**KIRKLEES METROPOLITAN COUNCIL
INVESTMENT & REGENERATION SERVICE**

DELEGATED DECISION TO DETERMINE PLANNING APPLICATIONS

Reference No:	2024/62/90223/E
Site Address:	Netherfield Mills, Calder Road, Ravensthorpe, Dewsbury, WF13 3JS
Description:	Change of use from car recycling workshop to skip hire and waste transfer station
Recommending Officer:	Nina Sayers

DECISION – Full Conditional Permission

DRG:  
PROPOSED SITE PLAN

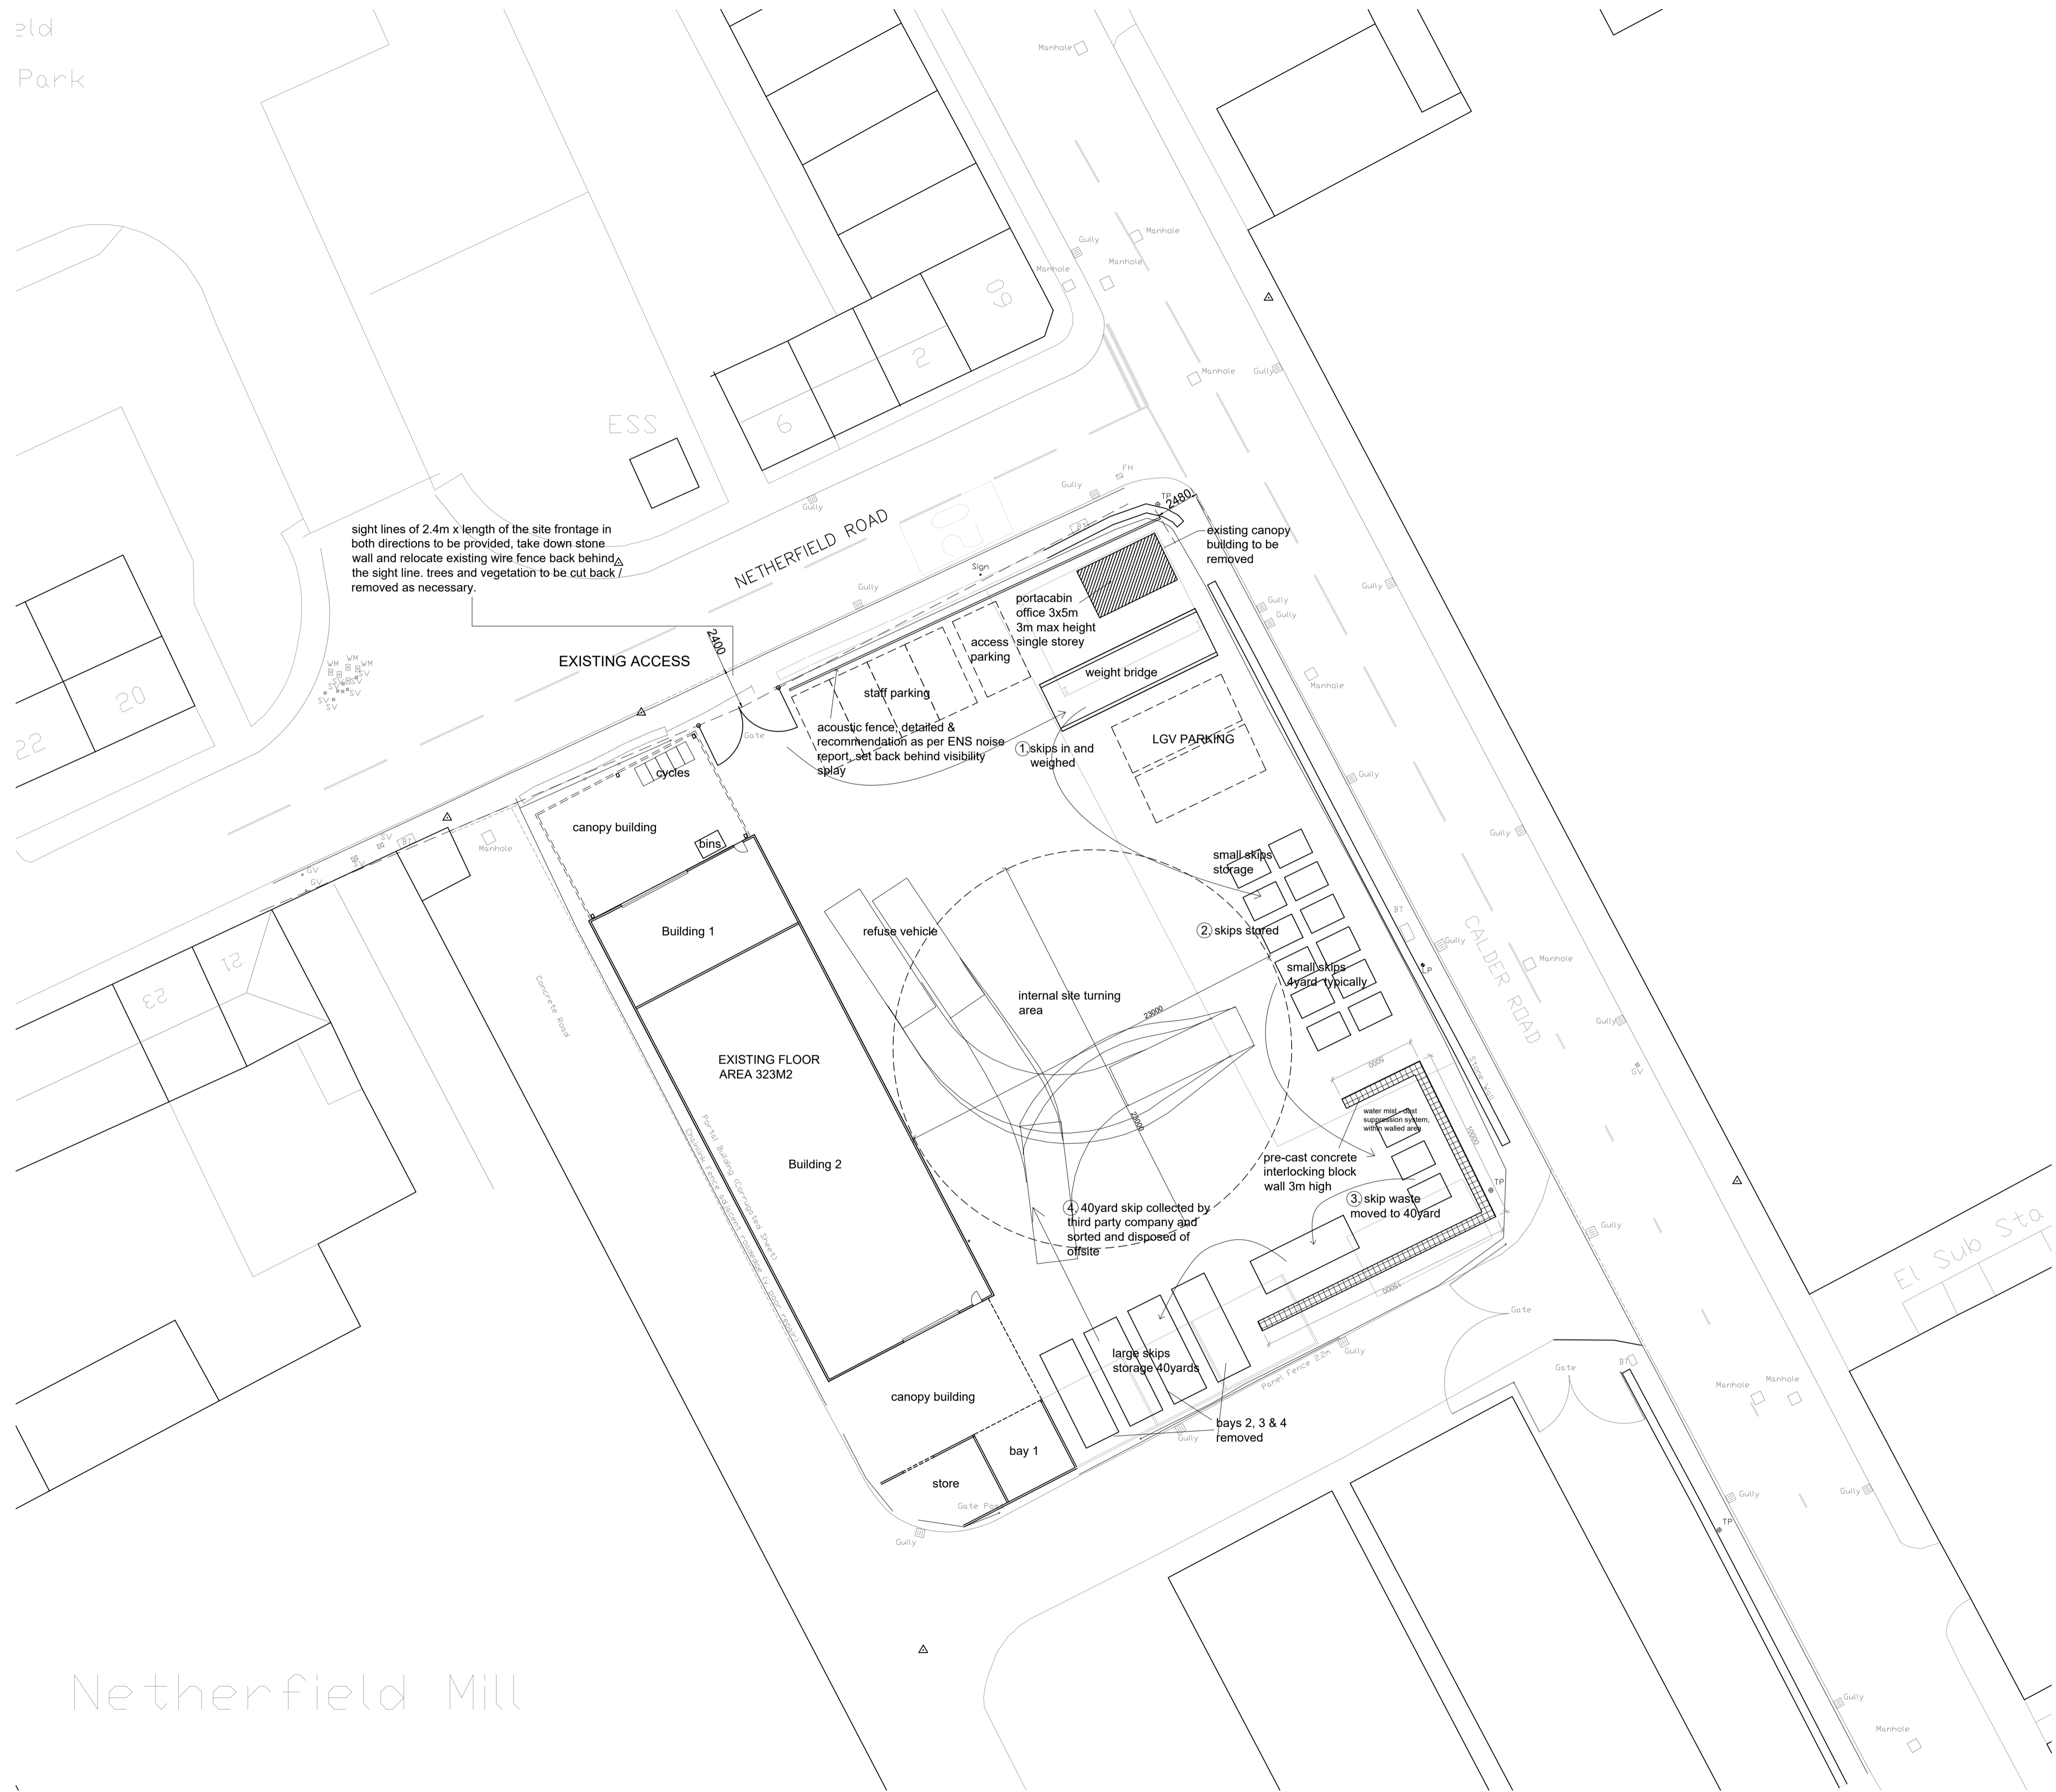
Kirklees Development Management Charter together with the National Planning Policy Framework and the DMPO 2015 encourages negotiation/engagement between Local Planning Authorities and agents/applicants. An amended site plan and supporting email was provided to address highway concerns as discussed in section 4 of this report. A revised site plan was also sought and provided to ensure the acoustic fencing did not interfere with visibility splays.

The proposed development would utilise the existing access off Netherfield Road and proposes 4 staff parking spaces, 2 LGV parking spaces, 5 cycle spaces and an internal HGV turning circle. KC Highways Development Management (HDM) were consulted on the proposal and initially requested additional information regarding anticipated traffic generation and skip hire vehicles and vehicle swept paths for the largest vehicle which would enter the site.

Officers requested the applicant set the required acoustic fencing in from the boundary of the site to ensure it did not interfere with the visibility splays at the site frontage, nor interfere with visibility at the Netherfield Road/Calder Road junction. An amended plan was received which relocated the acoustic fence, so as not to interfere with visibility.

4. Notwithstanding the details submitted within the Noise Impact Assessment, the acoustic fence shall be located as demonstrated on the hereby approved Proposed Site Plan '23.2746.02D'. The proposal shall otherwise comply with details submitted within the approved Noise Impact Assessment.

13. The development hereby approved shall not be brought into use until the visibility splays, as demonstrated on the approved Proposed Site Plan "23.2746.02D", have been cleared of all obstructions to visibility and remain clear for the lifetime of the development.

An amended site plan was provided which shows a swept path for a refuse vehicle, alongside an email from the agent confirming that the large skips are to be removed once per week, and 2 skip hire vehicle LGV onsite which would typically undertake 6 deliveries per day per vehicle. This information and amended plan were reviewed by KC HDM who, given the relatively low traffic generation, raised no objection to the proposal.
